Response to Comments

Project Name: English Crossing Townhomes
 Project File Number: PA23-012- Technical Review 1
 Review Completion: June 19, 2023

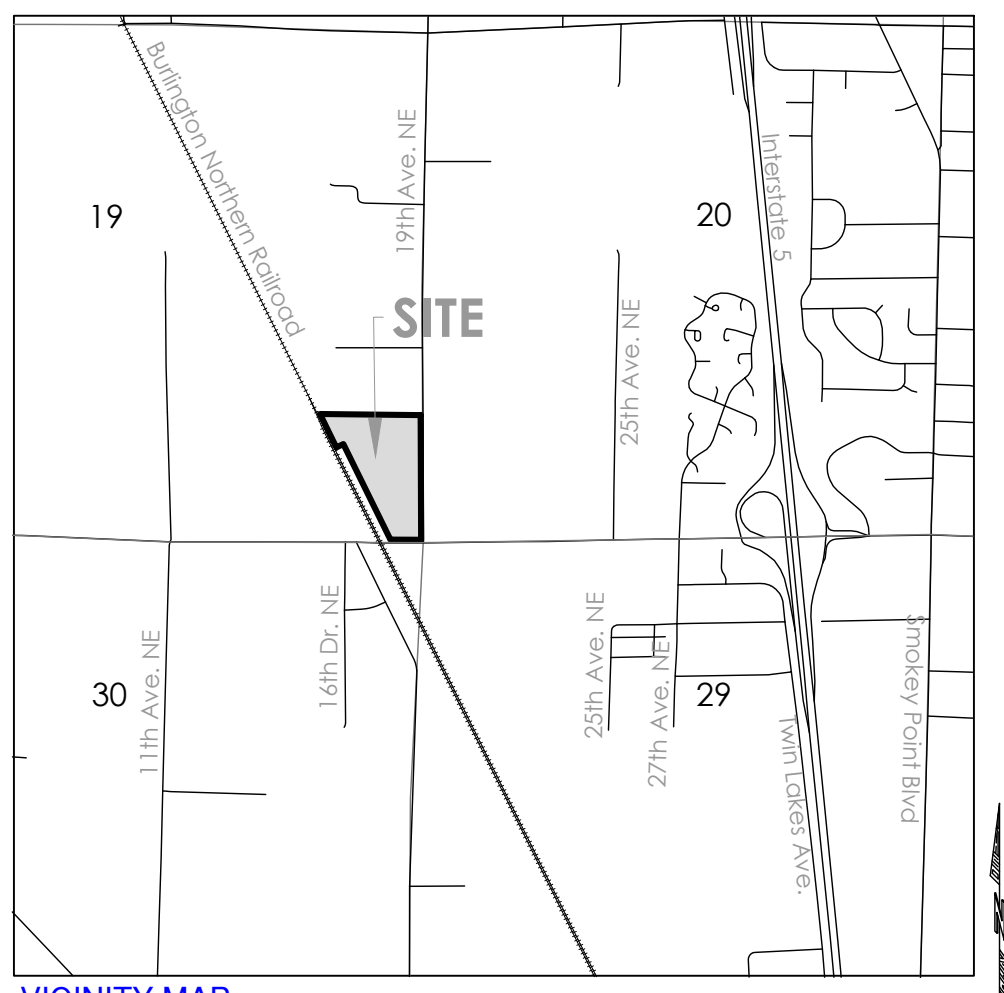
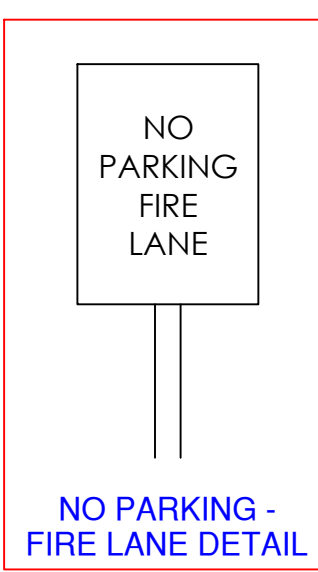
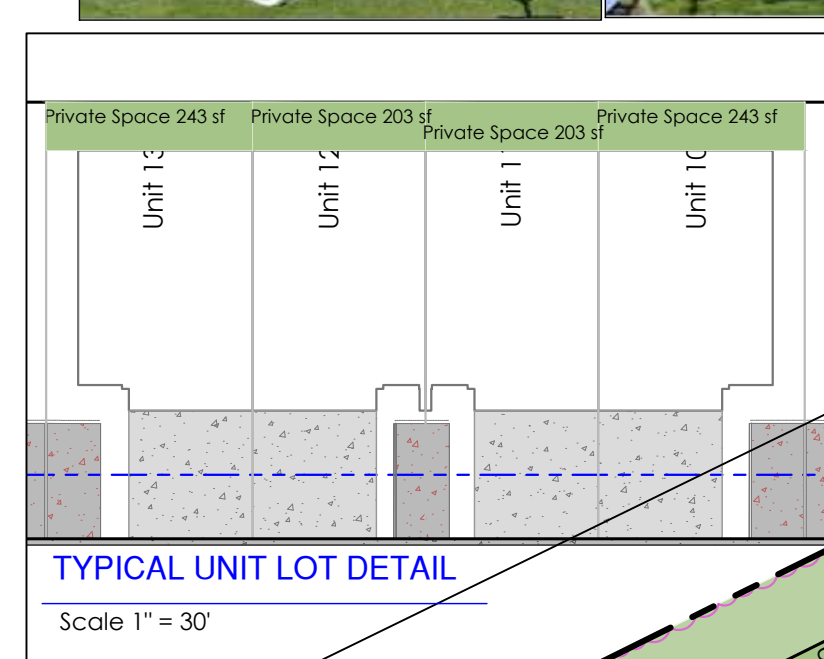
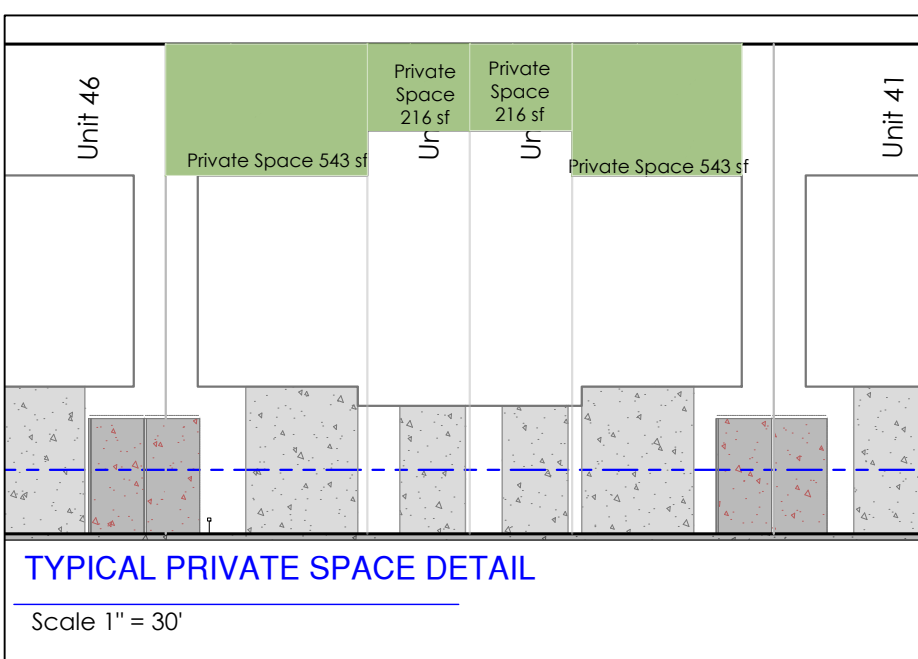
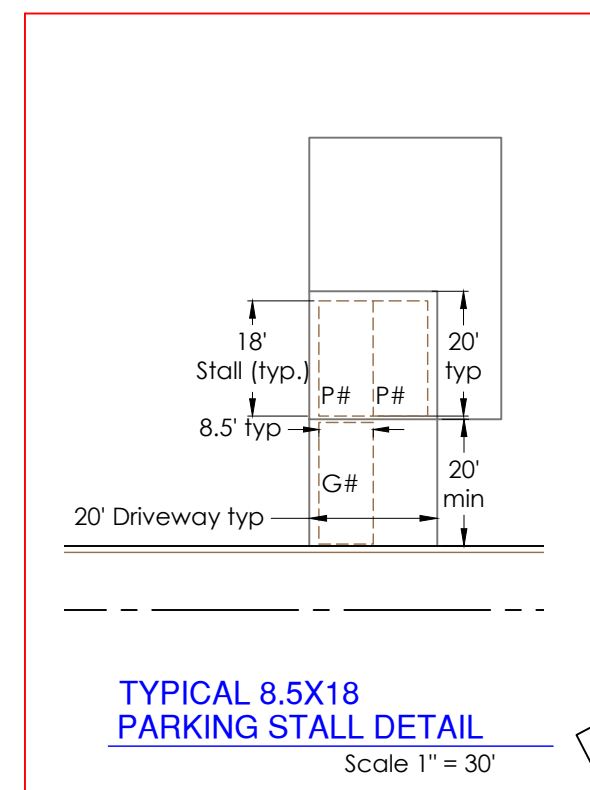
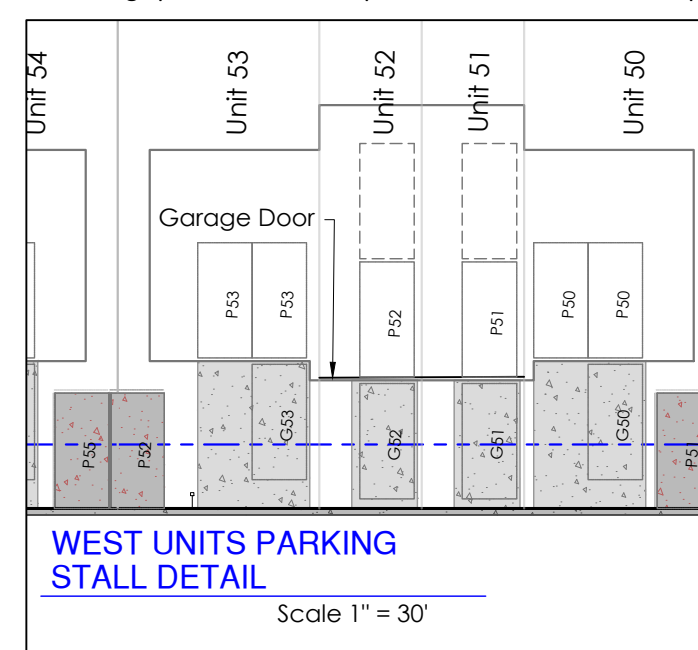
CITY COMMENTS	LAND TECH RESPONSE
<p>revised submittal. Please depict any proposed fencing on site plan.</p>	
<p>11. Fencing, in accordance with the fence standards in MMC 22C.065.120, will be required around the open space tracts adjacent to the roundabout and units adjacent to 172nd Street NE and 19th Avenue NE.</p>	<p>In accordance with the Fencing Ordinance listed, fences are provided between the Private Open Space and any Common Open Space.</p>
<p>12. Consistent with MMC 22C.065.120, fences adjacent to required common open space shall not exceed 4 feet in height.</p>	<p>MMC 22C.065.120(3)(d), the maximum can be 6 feet with the top two feet being open/lattice. That is per this proposal.</p>
<p>13. Consistent with MMC 22C.065.080, Townhouse open space, all townhouse developments shall provide at least 200 square feet of private open space per dwelling unit adjacent to, and accessible from, each dwelling unit. Please correct the reference on the site plan.</p>	<p>At least 200 sf of Private Open Space is provided per this proposal to each Townhome</p> <p>Not sure where this reference was.</p>

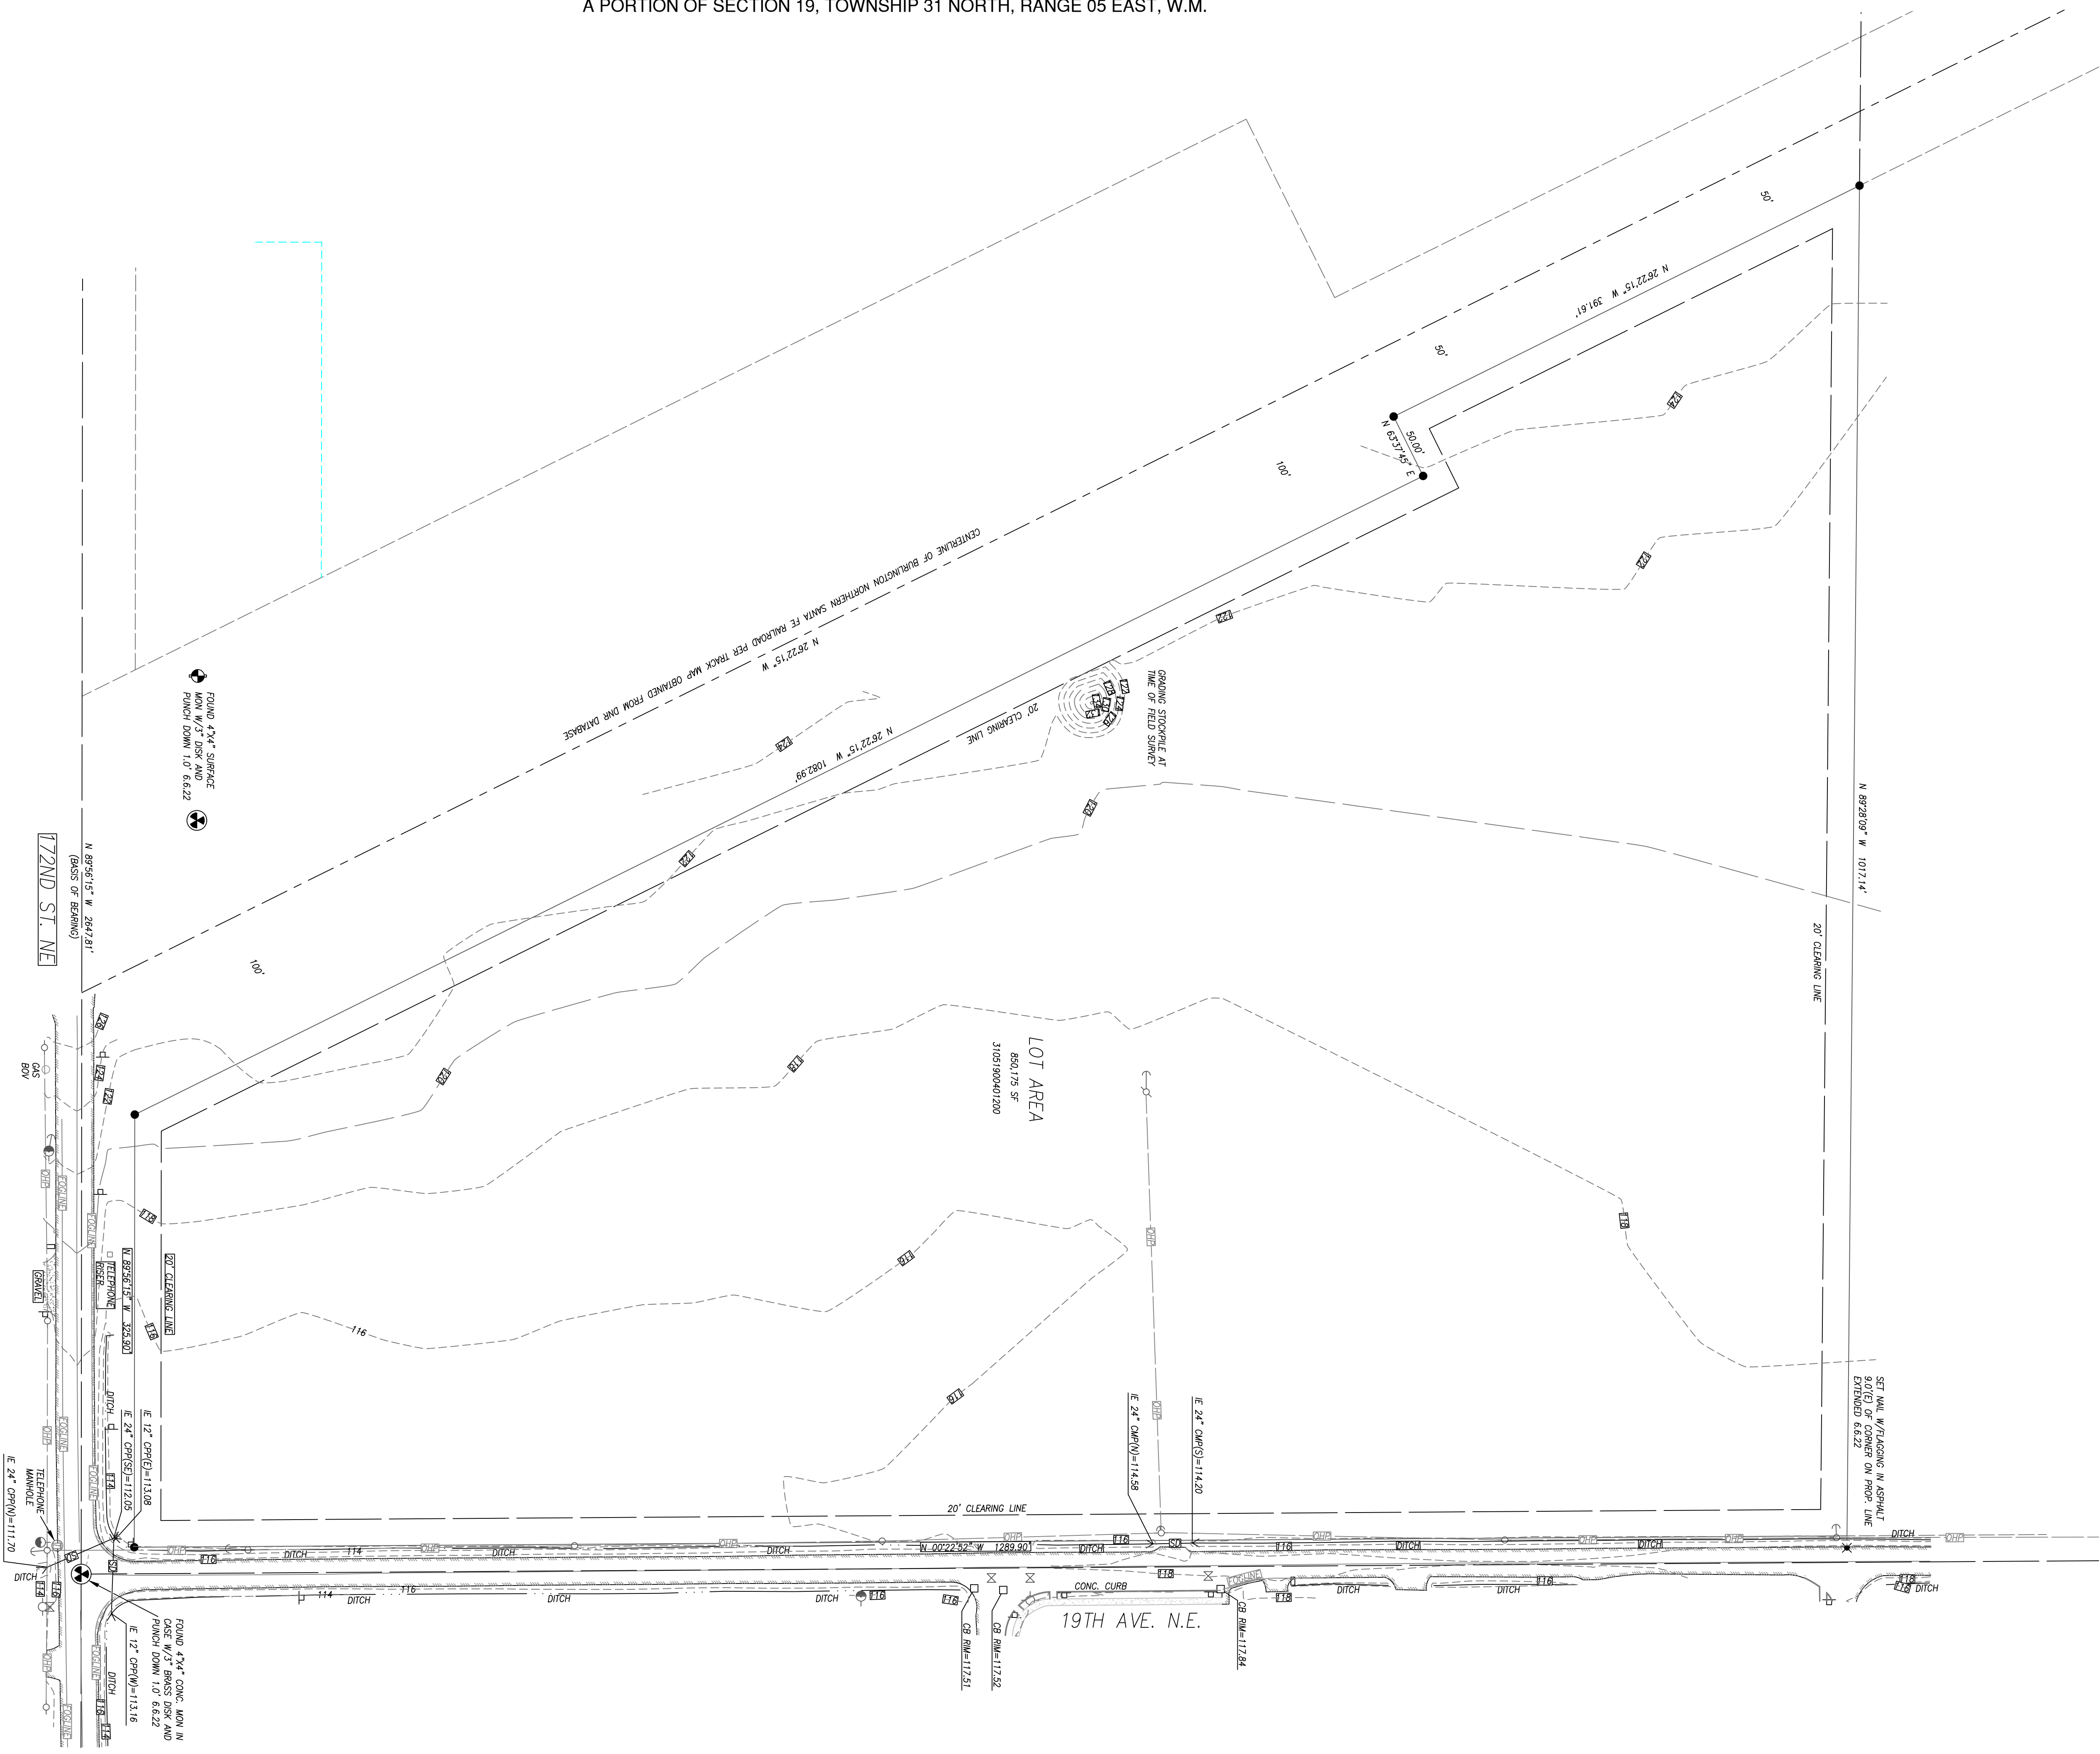
<p>14. Staff has concerns with the biocells that have a 4-5 foot grade change from the edge of unit yards (see units 93-103 as an example). These areas do not appear to be accessible. Is it possible to add access point with stairs or a more gradual slope into the area?</p>	<p>Biocells and inlets to biocells have been revised to limit grade change to 2' or less. This does mean using alternative conveyance options that move the water along the surface.</p> <p>We agree, 4 to 5 is too deep.</p>
<p>15. Street trees are required to be planted along all streets and access roads/easements, and should be separated from the roadway with planting strips. Street trees should be planted between the curb and the walking path of the sidewalk. Where planting strips are not incorporated into the design, street trees shall be located behind the sidewalk. Please revise the landscape plan to include street trees on all interior access roads.</p>	<p>These are all Private Drive Aisles and not Public Streets and landscape plan has incorporated trees along Drive Aisle Frontages.</p>
